**RE: NORTH SYDNEY MARIST COLLEGE MASTERPLAN
RESPONSE TO SUBMISSIONS – TRAFFIC AND PARKING**

A State Significant Development Application (SSDA) has been submitted, for the North Sydney Marist College Masterplan.

In response to the application, submissions have been received from authorities (TfNSW and North Sydney Council) and the community providing commentary on the traffic and parking assessment prepared by TTPP. The following responds to each of the traffic and parking related matters provided.

Figure 2.9: Existing Site Traffic

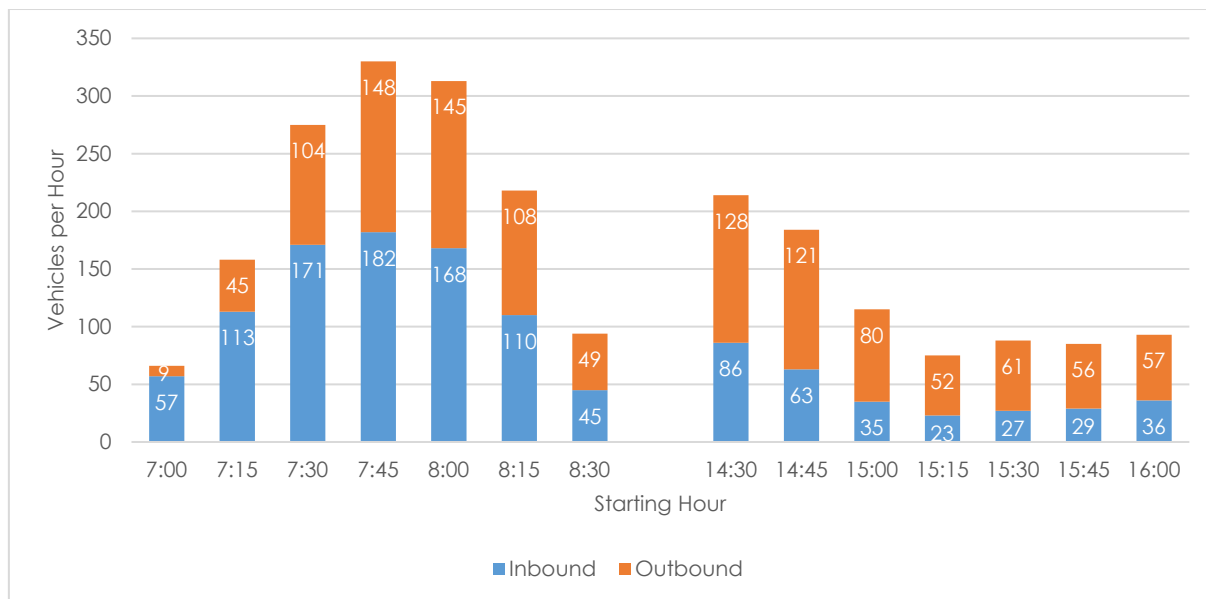
2. Page 39 - 7.2 - The 'evening peak (2:30pm-4:30pm)' used in the Base Model appears unusual. Around the same time in 2019, it appears to show later PM peak times (please see attachments).

A 2.30pm-4.30pm peak is usual for an area around a school and is supported by the traffic survey data. A copy of the survey data is provided in **Attachment One**. In addition, there is very little school traffic during the 'typical' road network peak hours (4pm-6pm), therefore, it is more conservative to assess the development impact during these hours. After 4pm, the development impact is expected to be minimal, if any.

Comparatively, the TIA provides a summary of traffic surveys undertaken by TPPP for the existing site which demonstrates the site traffic generated during school pick up period (2:30pm-4:30pm), is up to 214 vehicles per hour. It indicates that the 'typical' road network peak is minor in comparison to the evening peak assessed (2:30pm-4:30pm) in the TIA.

Figure 4.2: Carlow Street Access

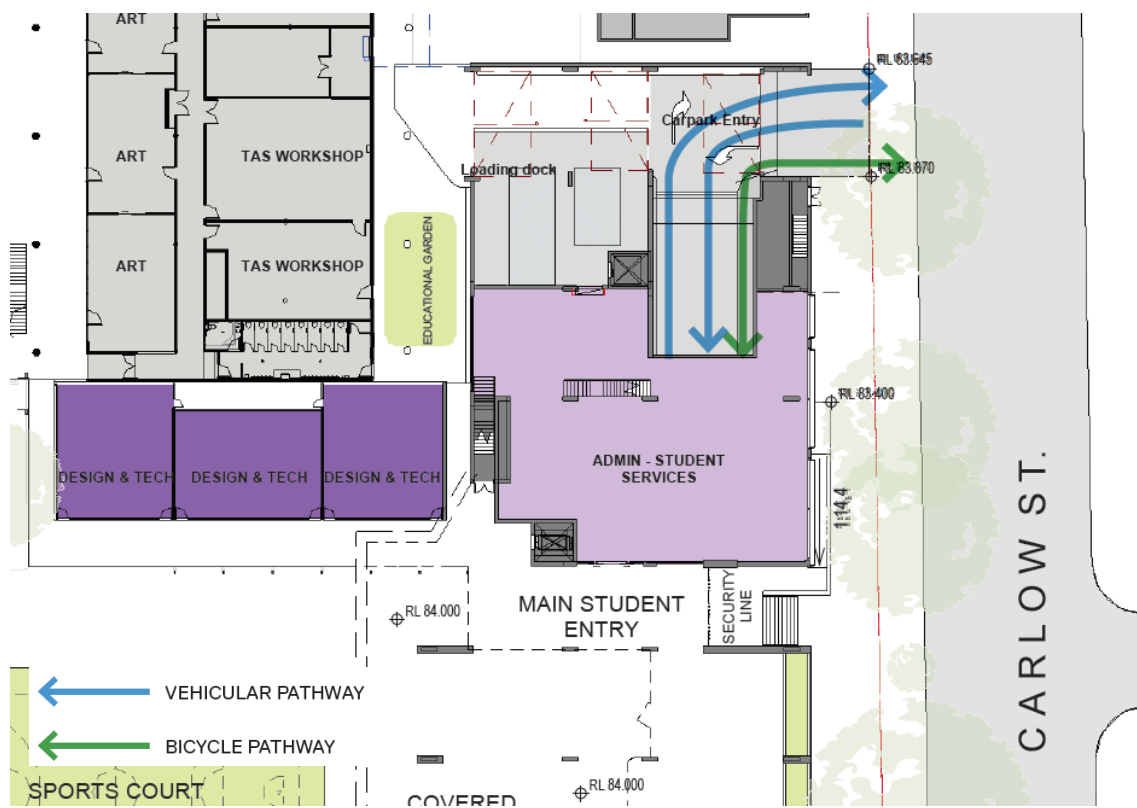
8. The proposed Carlow Street car park would provide 50 spaces proposed for staff, compared to 44 existing spaces. Proposed parking spaces for staff should remain at the existing 44 spaces to discourage car use and increase non-car mode share for travel to and from the site. The provision of 44 parking spaces for staff parking aligns with Educational SEPP. Measures to discourage staff from using St Mary's Church / Parish Office parking (41 spaces) should be included in the updated Green Travel Plan (GTP).

The development be conditioned to provide a maximum of 44 parking spaces for staff in the proposed Carlow Street car park.

The TIA indicates that there are 63 spaces regularly used by staff currently, including 44 formal spaces and 19 informal spaces, as per extract below.

As per Table 4, the parking spaces available to staff currently equates to 63 spaces. In the future, staff will have 56 spaces available for use. Staff parking provision has therefore reduced.
